The Planning Inspectorate  
Yr Arolygiaeth Gynllunio

## Acceptance of Applications Checklist

## Byers Gill Solar Section 55 Acceptance of Applications Checklist

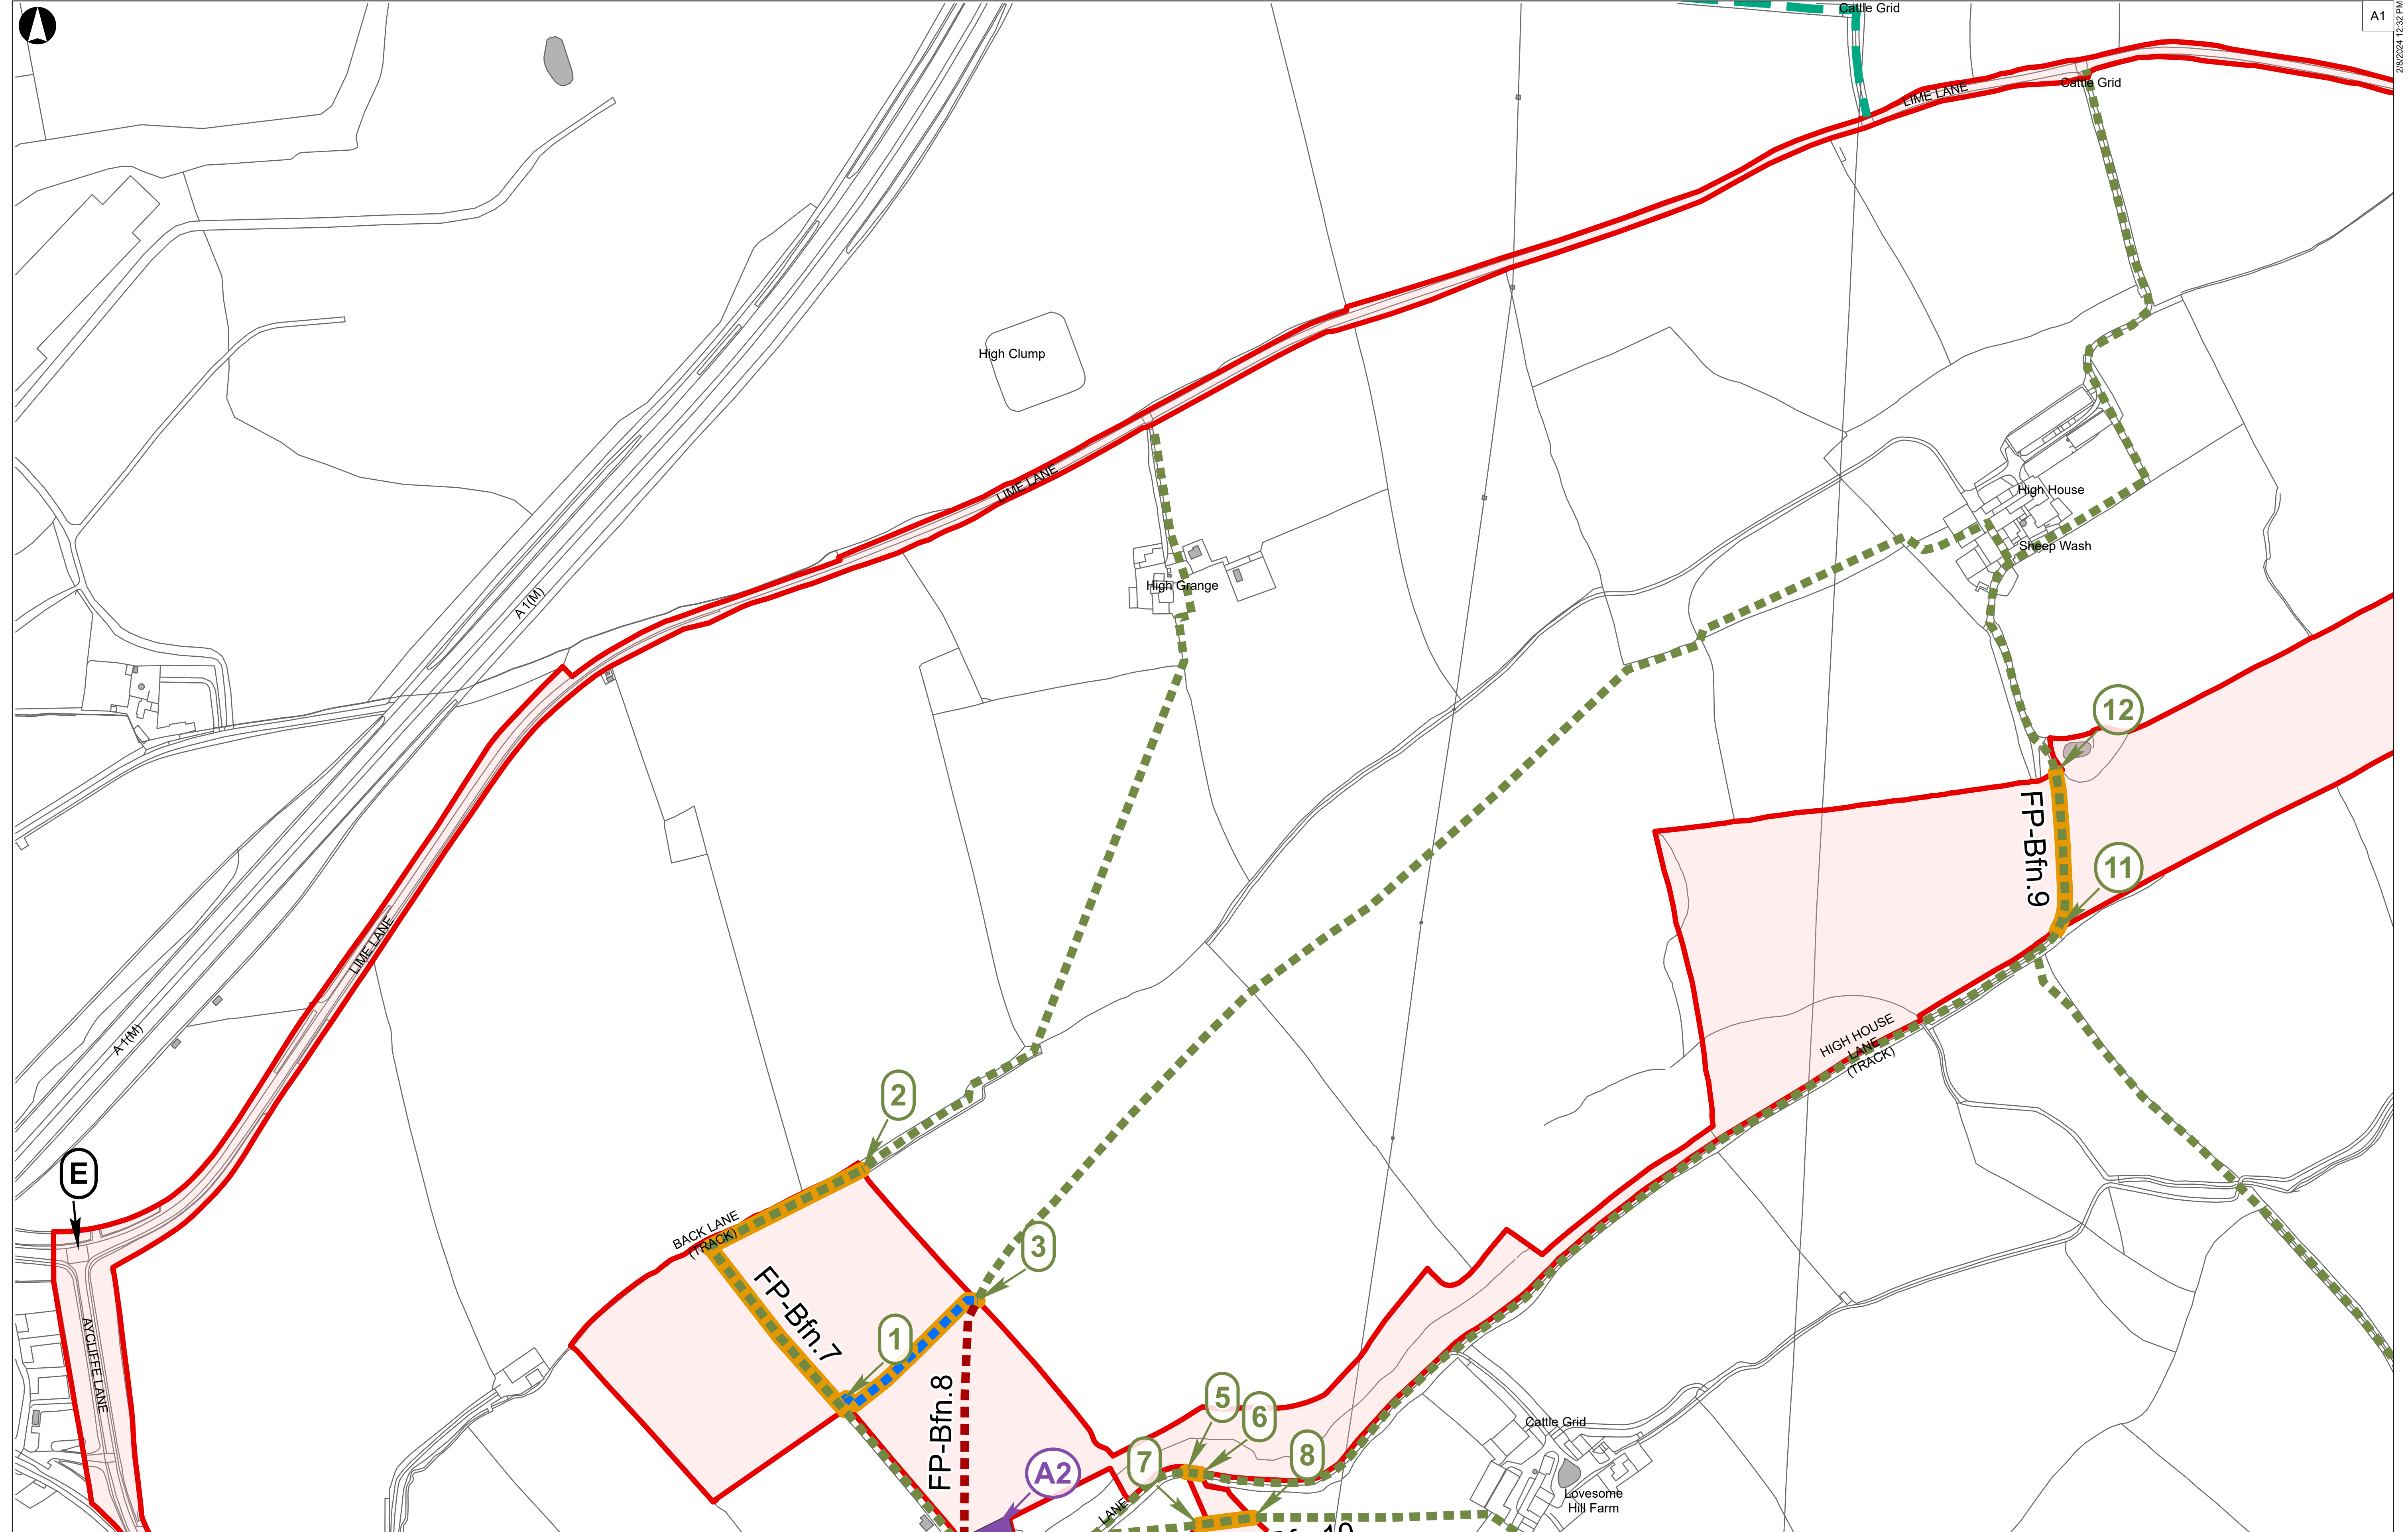
across all plans. In addition to this, the order of the sheets in the **Street Works, Rights of Way and Access Plans (Doc 2.3)** is not the same to that of the Key Plan included in the **Works Plans (Doc 2.2)** or the **Land Plan (Doc 2.4)**. The **Street Works, Rights of Way and Access Plans (Doc 2.3)** does not appear to actually match the layout of the key plan and does not appear to correspond to the order in which the sheets of the **Street Works, Rights of Way and Access Plans (Doc 2.3)** are actually set out.

Order of the sheets in Key Plan does not match the order in the Works Plan or the Land Plans and does not seem to correspond to the order that the Public Rights of Way Plans are set out. Applicant is requested to clarify this point.

Please refer to further section 51 advice provided following Acceptance.
